**COWAL GOLD OPERATIONS
PROCESSING RATE MODIFICATION**

**Response to Submissions
2018**

JUNE 2018
Project No. HAL-16-41
Document No. 00918198-001

CGO PROCESSING RATE MODIFICATION
Biometric Vegetation Type Not Requiring Offset

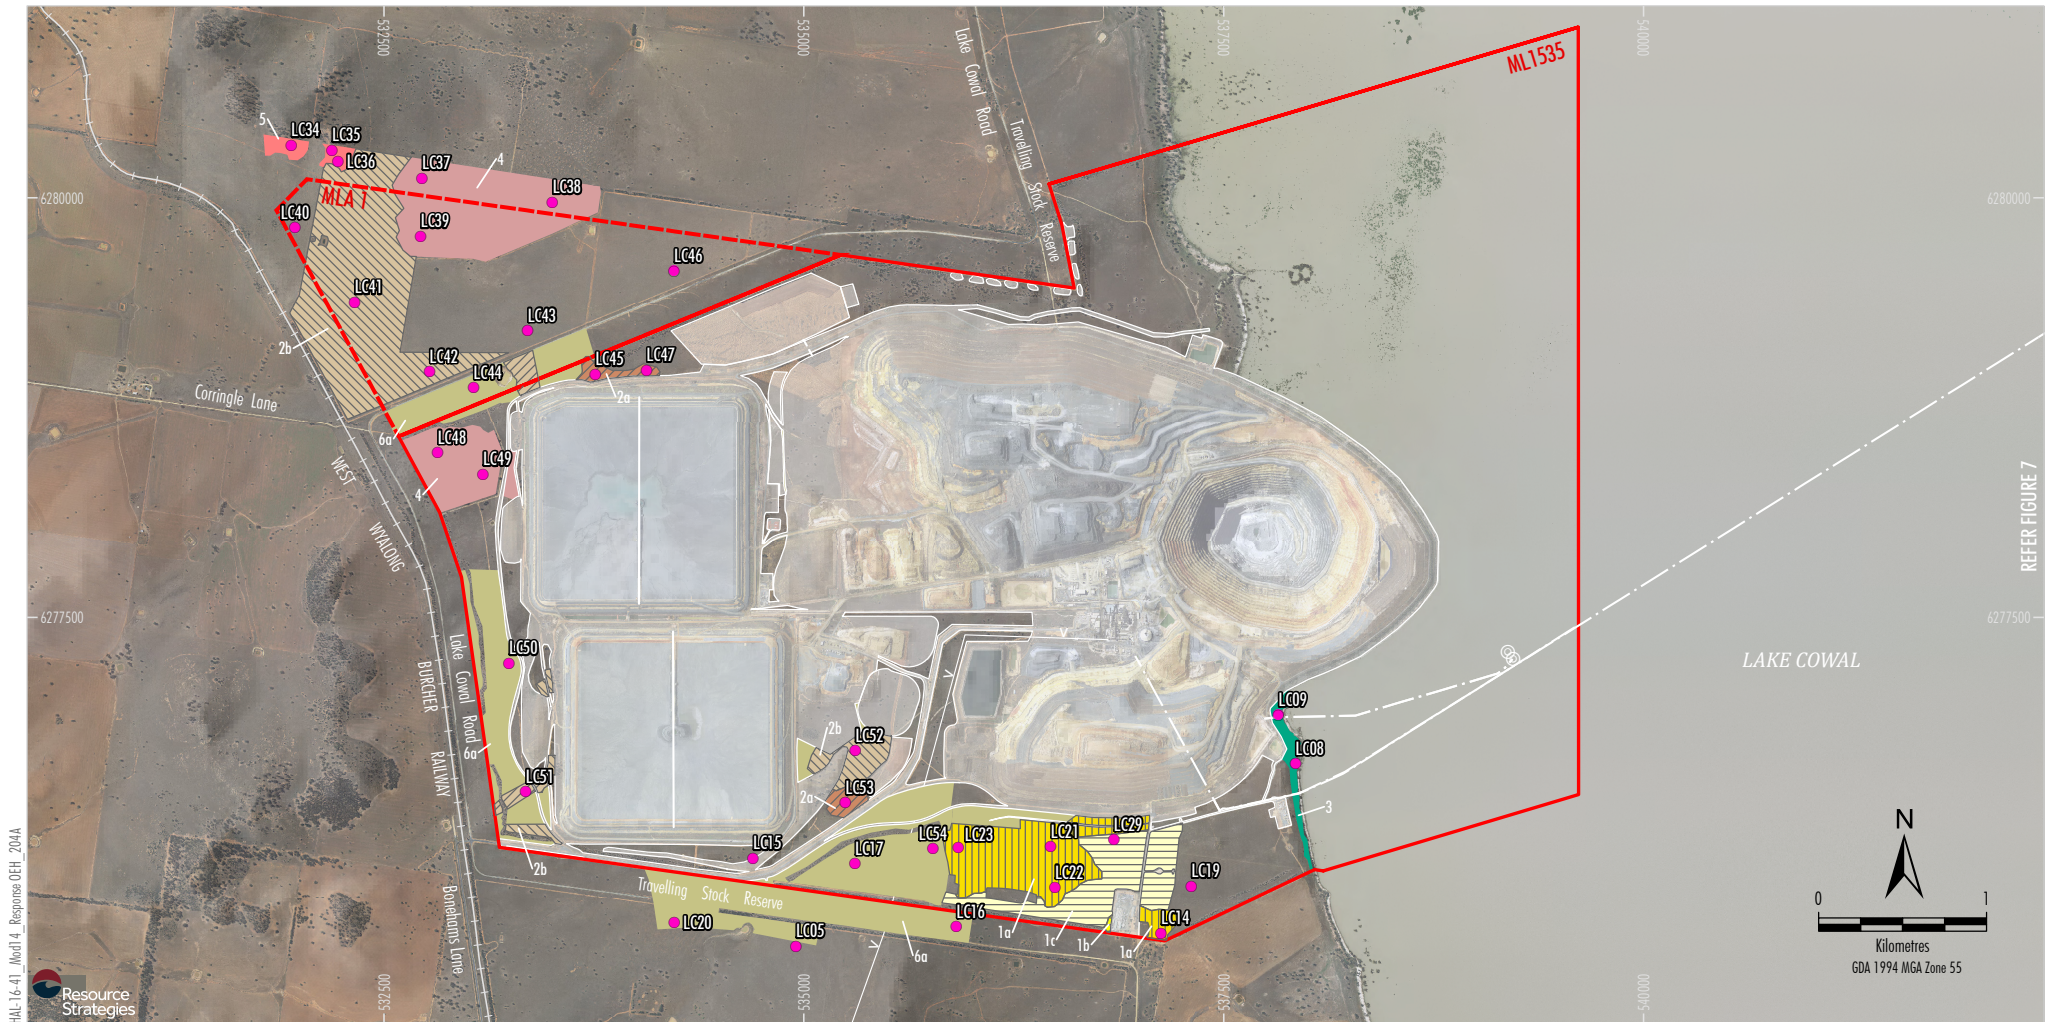
Maps listed in Table 21 (FBA Appendix 7, page 102) as required for the Impact Summary section have not been individually included. While the information is included in earlier parts of the BAR, providing the required maps would be helpful given there are two assessment areas.

Figures 3 to 8 provides the relevant mapping as requested by OEH.
